PROPOSED NORTHCONNEX M1 / M2 TUNNEL PROJECT - Application Number - SSI 13_6136

We object to many aspects of this project

MOTORWAY OPERATIONS COMPLEX - SOUTHERN VENTILATION FACILITY - SECTIONS
M1-M2-5000-DR-JD-0525

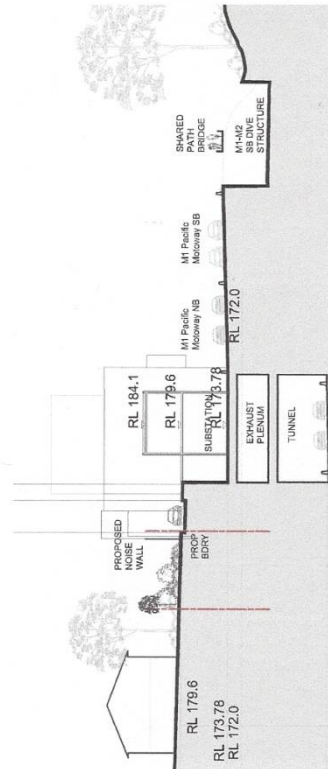
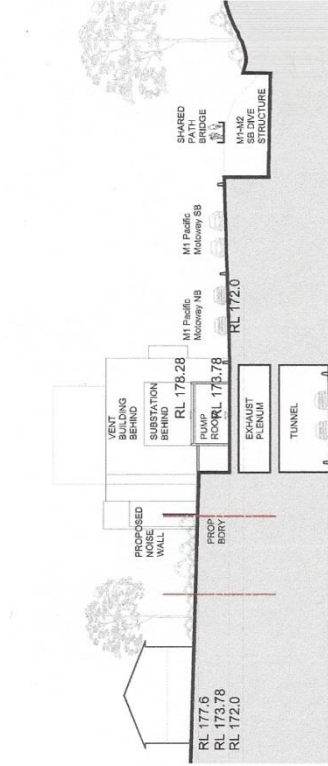
1. The Environmental Impact Statement (EIS) does not show any connection between the ventilation stack and the southbound tunnel which is 250 metres away. Will the polluted air be allowed to flow like an invisible sewer through West Pennant Hills, North Rocks, Carlingford and Beecroft?
ACTION: Provision of diagrams and detailed description of what ventilation is proposed for the southbound tunnel at the Southern Interchange. We would like the opportunity to lodge further submissions once that has been provided.

2. The ventilation stack should be located immediately above the tunnels on the corner of the Pennant Hills Golf Course and the M2. NorthConnex admit that this is the most efficient location for the stack. Why is the stack not being correctly located and positioned as far as possible away from homes?
ACTION: Purchase of golf course land to position the stack in its most effective location.
